Subject: RE: BR/281/18/PL 99 Victoria Drive, redevelopment with flats

I have been looking at the application plans today and I have a couple of comments:

PROPOSED FIRST FLOOR PLAN

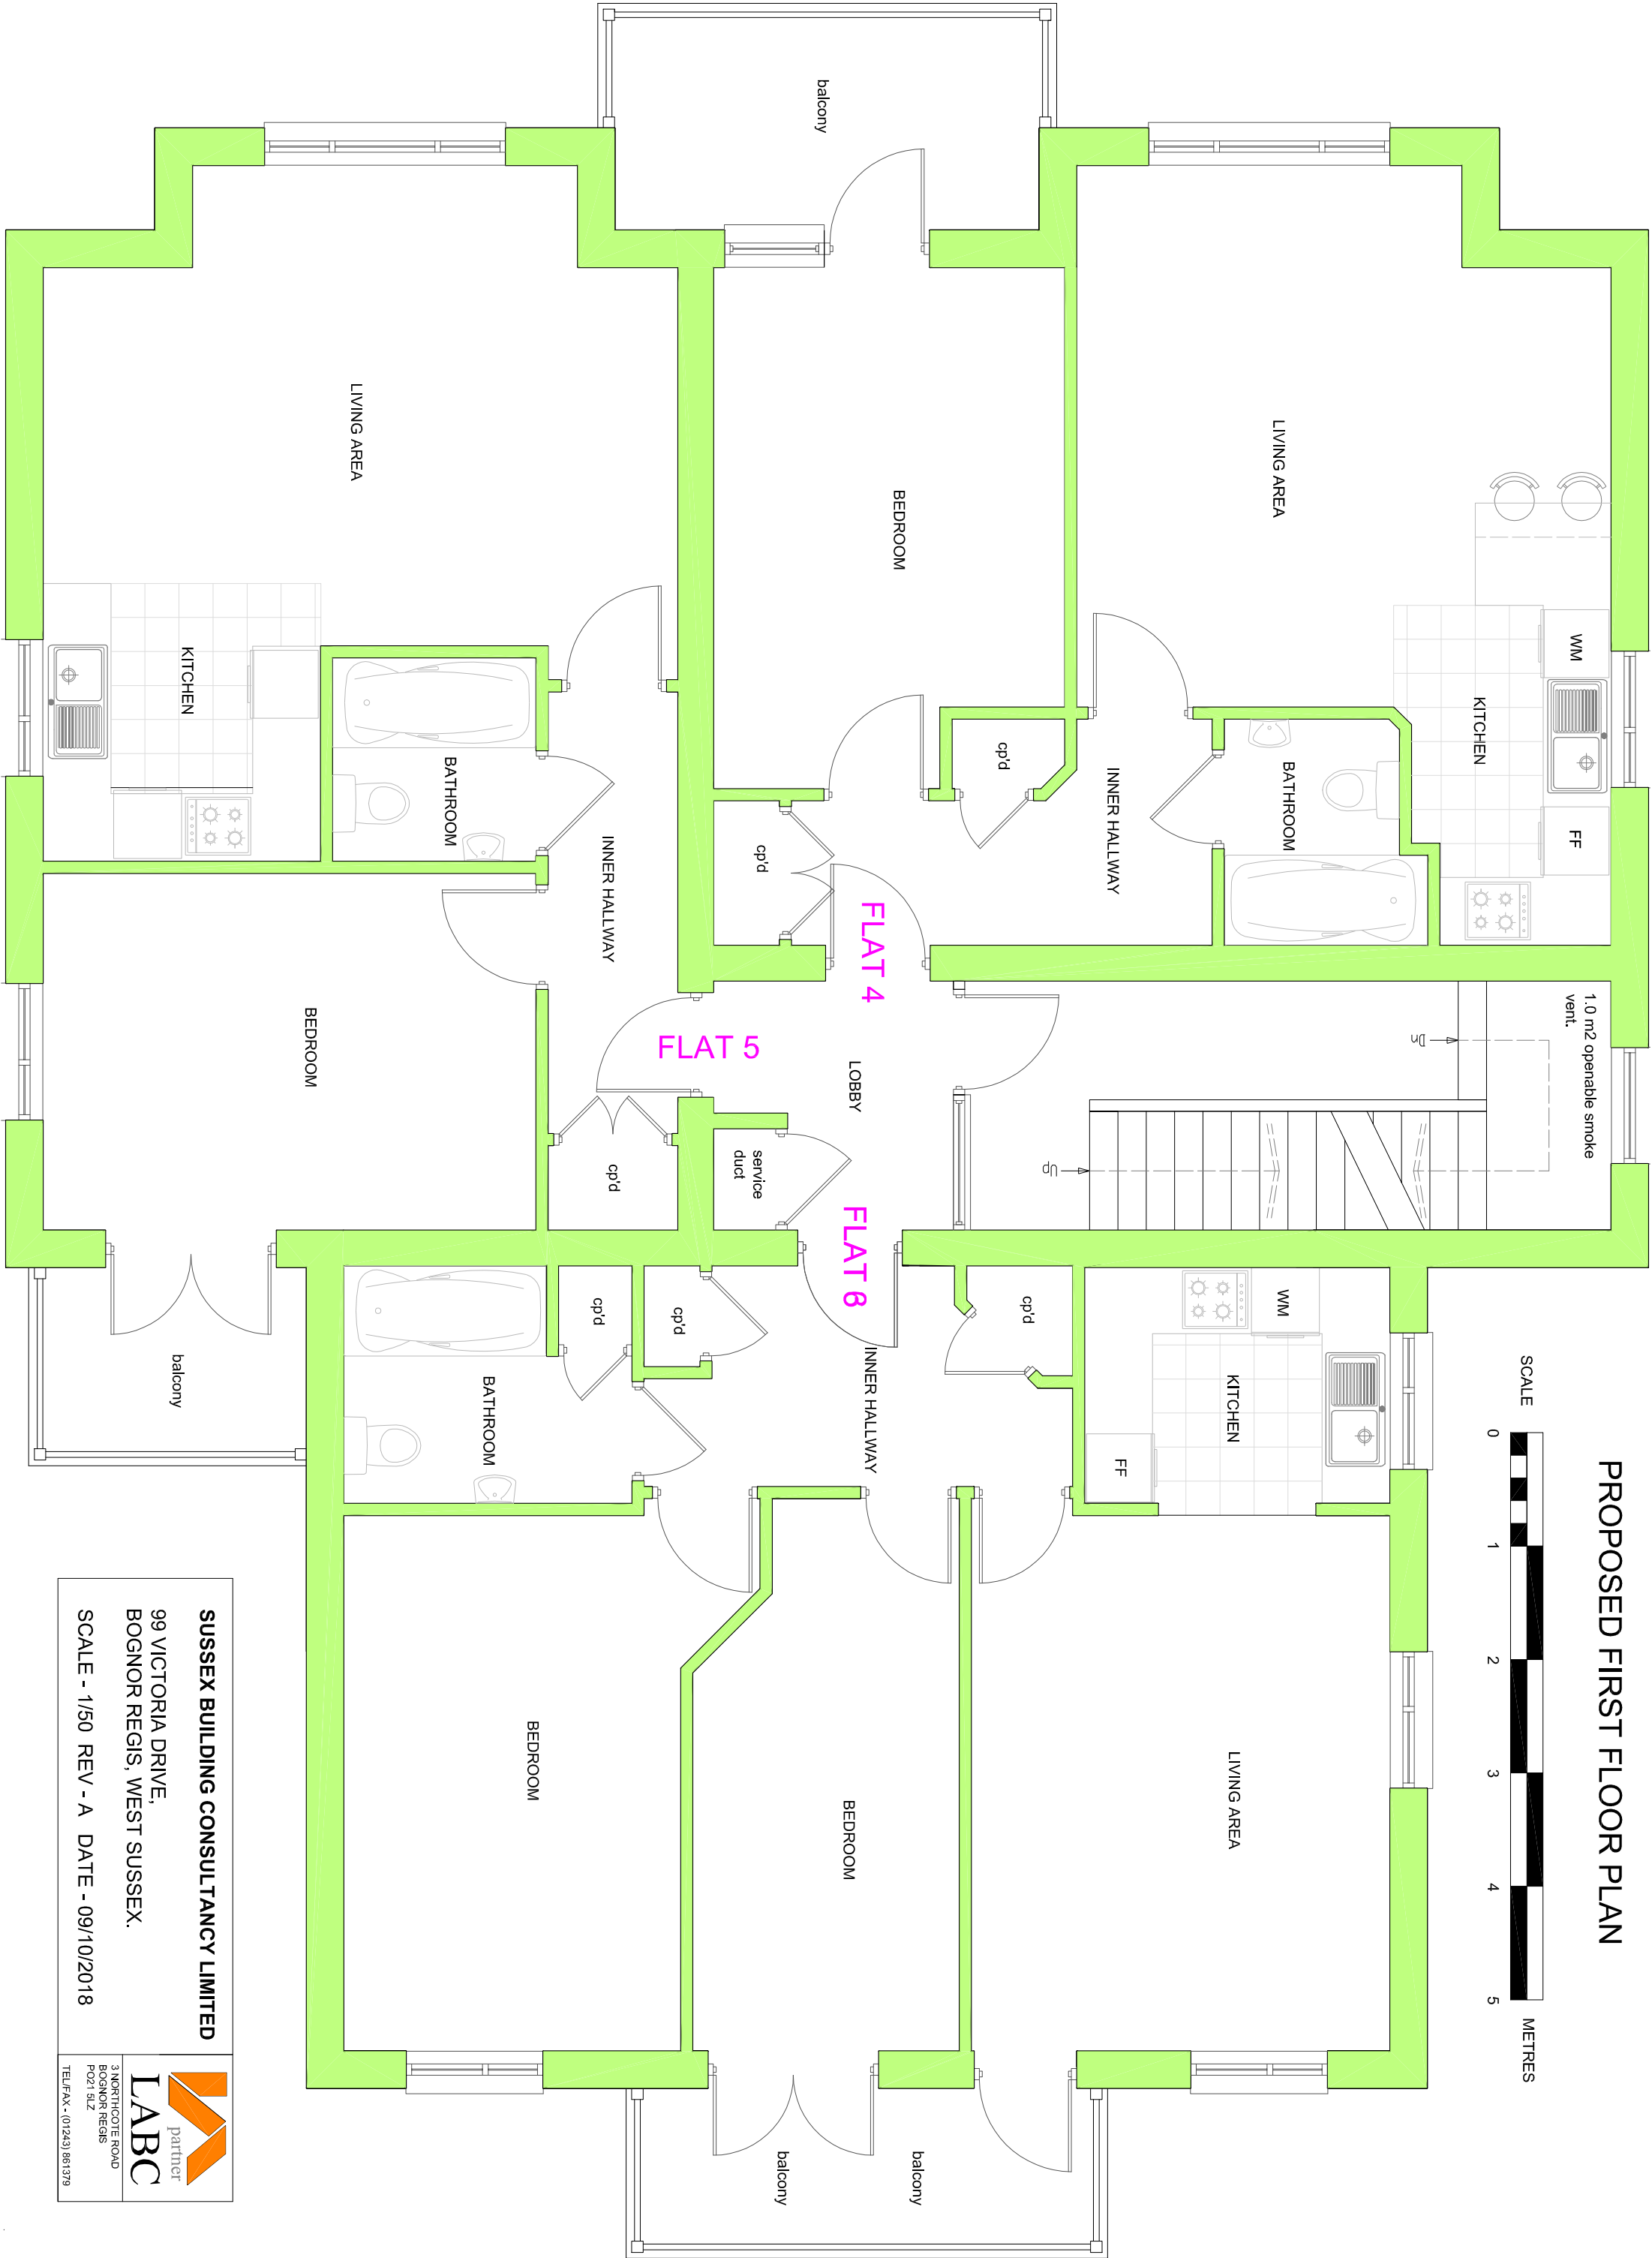
Firstly, we will require that the sides of the rear balconies (including the NE facing side of the balcony to flat 5) be fitted with privacy screens up to 1.7m height – either solid material or o/g glass). Can you provide amended drawings to show this.

Secondly, I will likely require that all first & second floor flank windows be o/g and fixed shut up to 1.7m from the floor level. I note that all of these proposed flank windows are secondary in nature so don't consider this to be a problem but can you advise whether you can agree to this. I note that there was a condition attached to the permission for the flats at 101 (BR/155/06/) that all flank windows were to be o/g so consider there to be precedent for my request. If you agree, can you provide amended drawings to indicate this.
